DRB Application No.: 04DRB-00102 (P&F)
Project Name: PEREA ADDITION
Agent: Kevin & Mary Murrigh

Project # 1002775
EPC Application No.: _____
Phone No.: 610-1230

KEVIN & MARY MURTAGH request(s) the above action(s) for all or a portion of Lot(s) 1 & 2, Block(s) 39, **PEREA ADDITION**, zoned SU-2 TH, located on GRANITE NW, between MOUNTAIN NW and 12TH ST NW containing approximately 1 acre(s). [REF: 03DRB-01042, 03DRB-01703] (J-13) **PRELIMINARY PLAT WAS APPROVED WITH FINAL SIGN OFF DELEGATED TO PLANNING FOR PROPERTY MANAGEMENT'S SIGNATURE AND AGIS DXF FILE.**

RE: Lots 1 & 2, Block 39, Perea Addition/minor plat

PLAT OF  
 LOTS 1-A & 2-A, BLOCK 39  
 PEREA ADDITION  
 SITUATE WITHIN SECTION 18,  
 T. 10 N., R. 3 E., N.M.P.M.  
 CITY OF ALBUQUERQUE  
 BERNALILLO COUNTY, NEW MEXICO

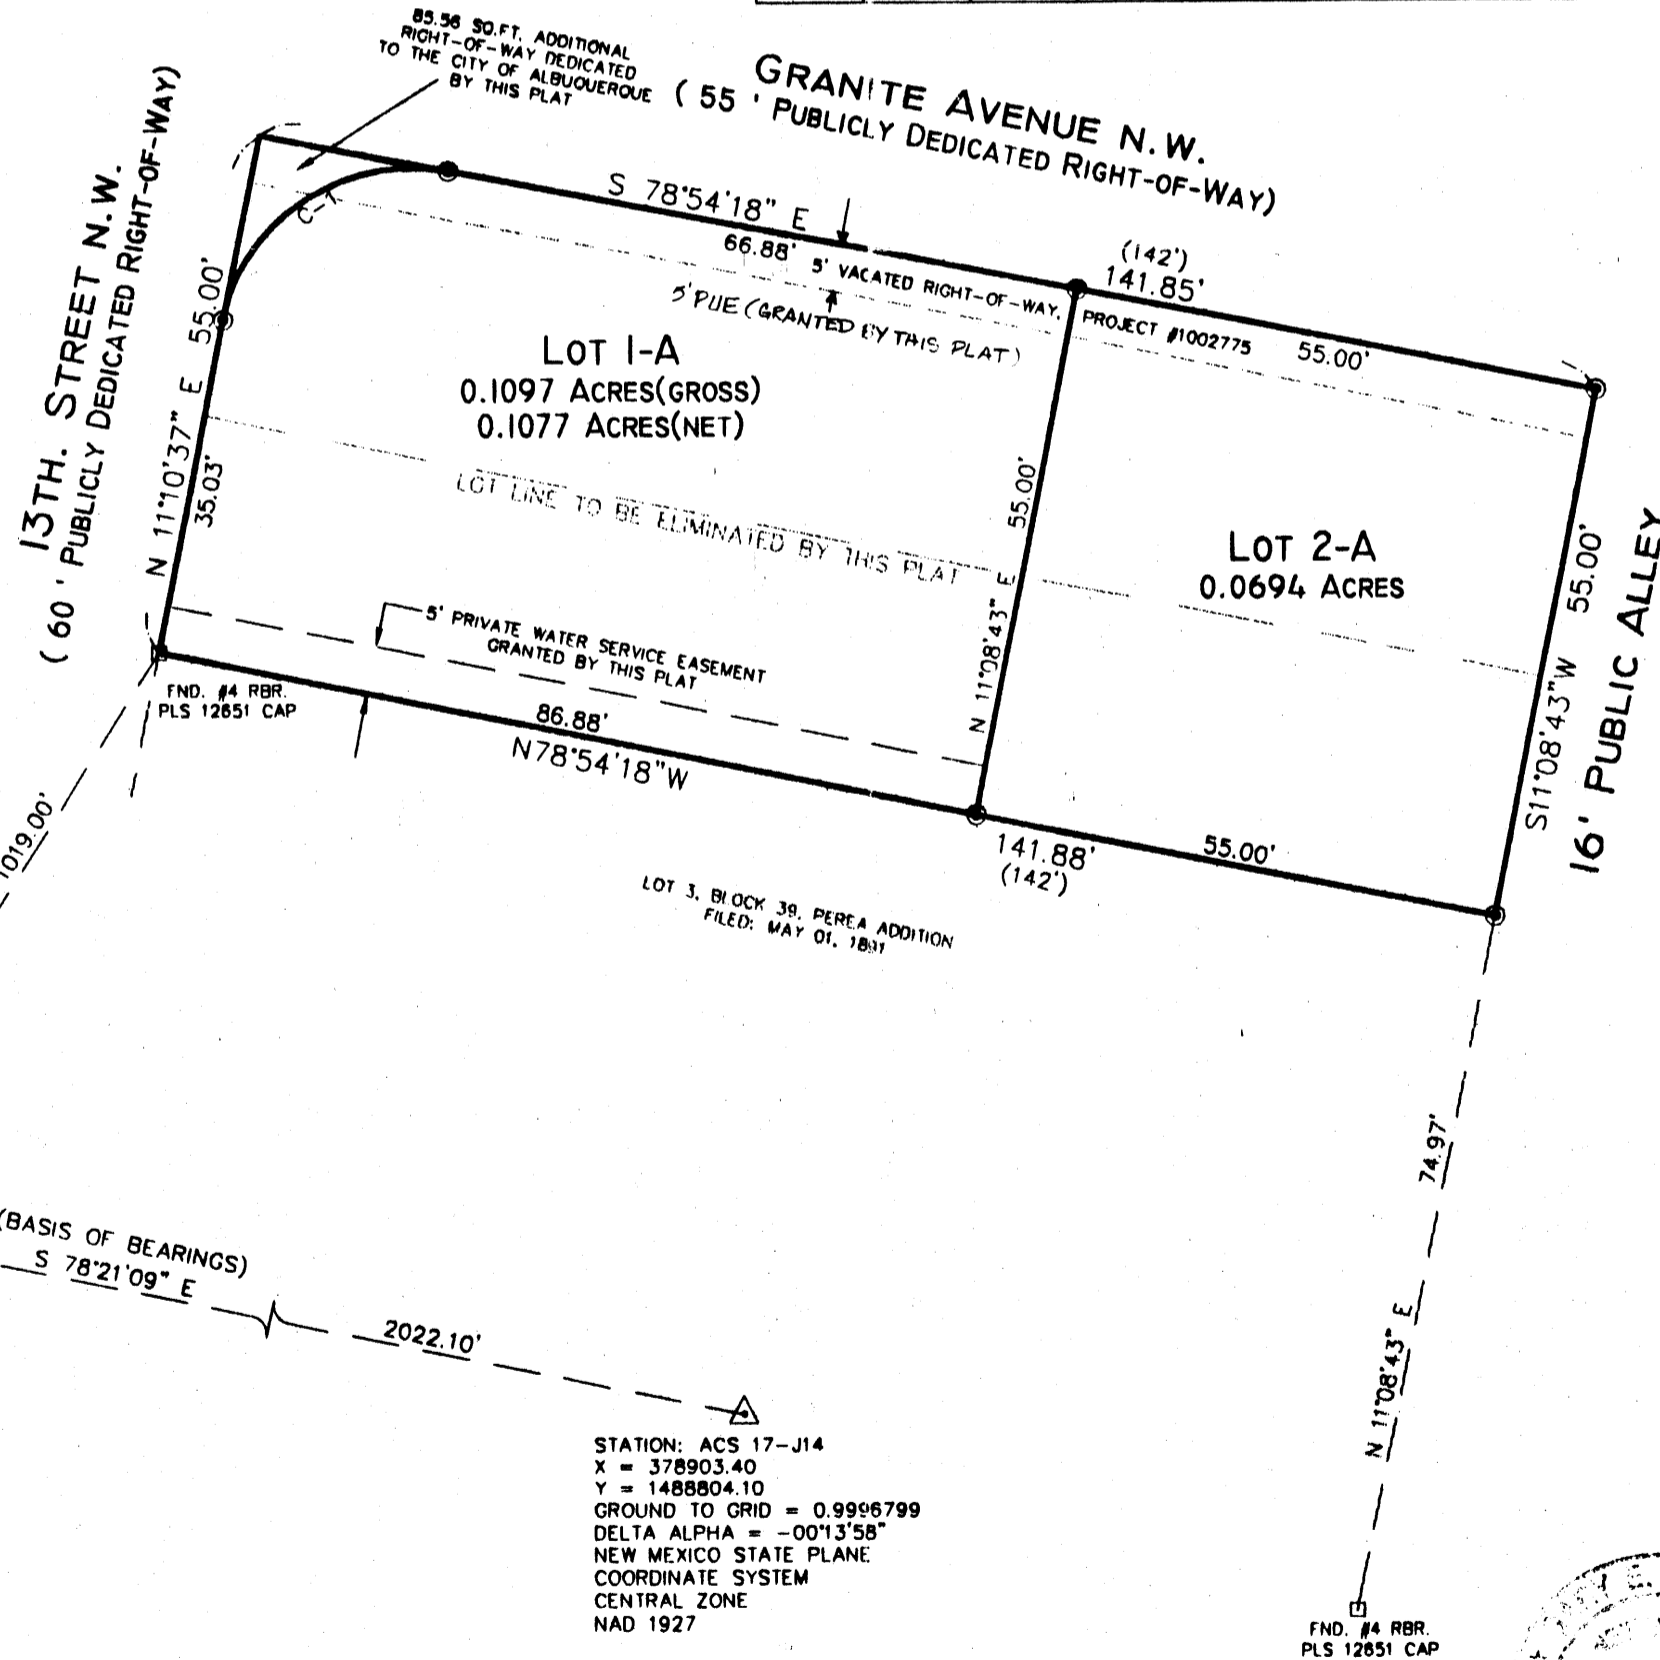
| No. | Comment |
|-----|---|
| ① | WHERE WILL LOTS TAKE ACCESS FROM? (ANY??) |
| ② | IS SIDEWALK IN PLACE? IF NOT SIA WILL BE REQUIRED |

Dedication of radius @ 13th & Granite (20') is required. Infrastructure list required for sidewalk.
